CITY OF ALBUQUERQUE

RE: PNM Girard Substation Improvement
Grading and Drainage Plan
Engineer's Stamp Date 12-22-2016 (File: L20D071)

Based upon the information provided in your submittal received 12-22-2016, the above referenced Grading Plan is approved for Grading Permit Approval and SO19 Approval, based on the following conditions:

CITY OF ALBUQUERQUE PLANNING AND DESIGN DIVISION			
PROJECT TITLE: PNM GIRARD SUBSTATION IMPROVEMENTS			
TITLE:			
Design Review Committee	City Engineer Approval	Mo. / Day / Yr.	
Last Design Update		Mo. / Day / Yr.	
CITY PROJECT NO.		ZONE MAP NO. H-16-Z	DWG. SHEET OF

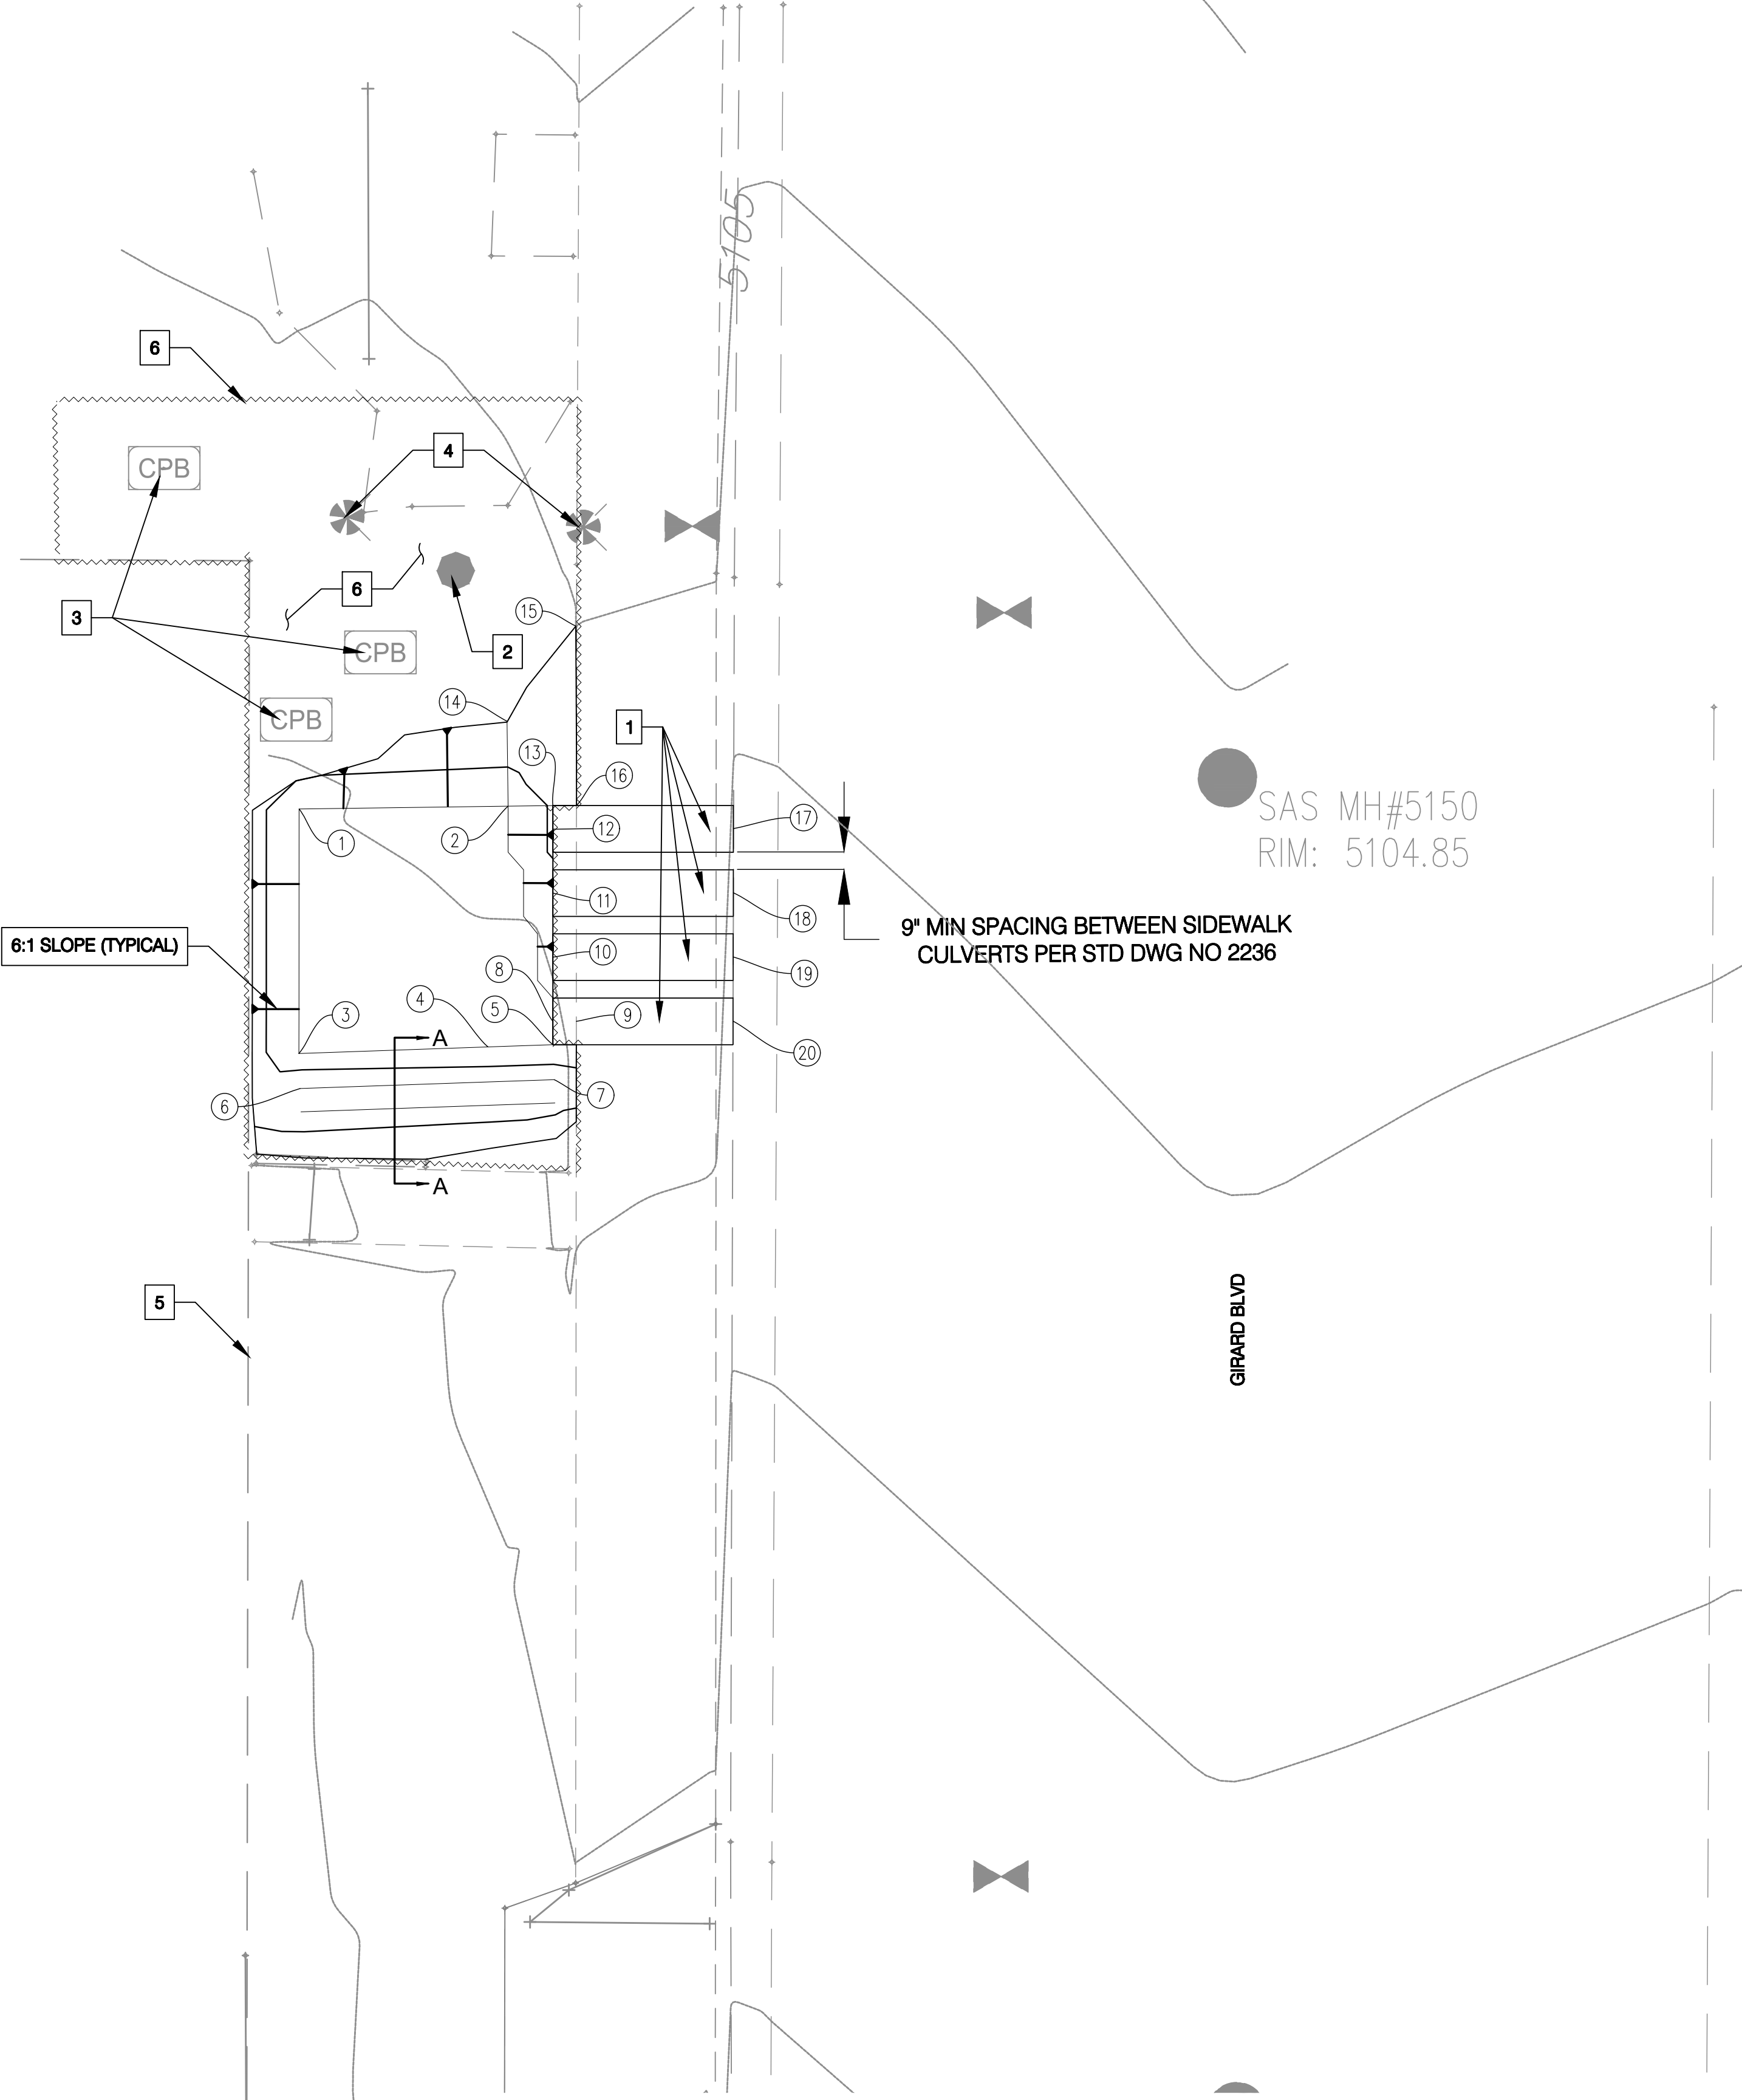
1. Extend sidewalk culvert and plate 12 inches behind the sidewalk if back of sidewalk at property line. If the back of the sidewalk is not at property line the sidewalk culvert and plate must be extended to the property line.
2. Tack weld bolt at the plate.
3. Call Jason Rodriguez at 235-8016 for sidewalk culvert inspection.
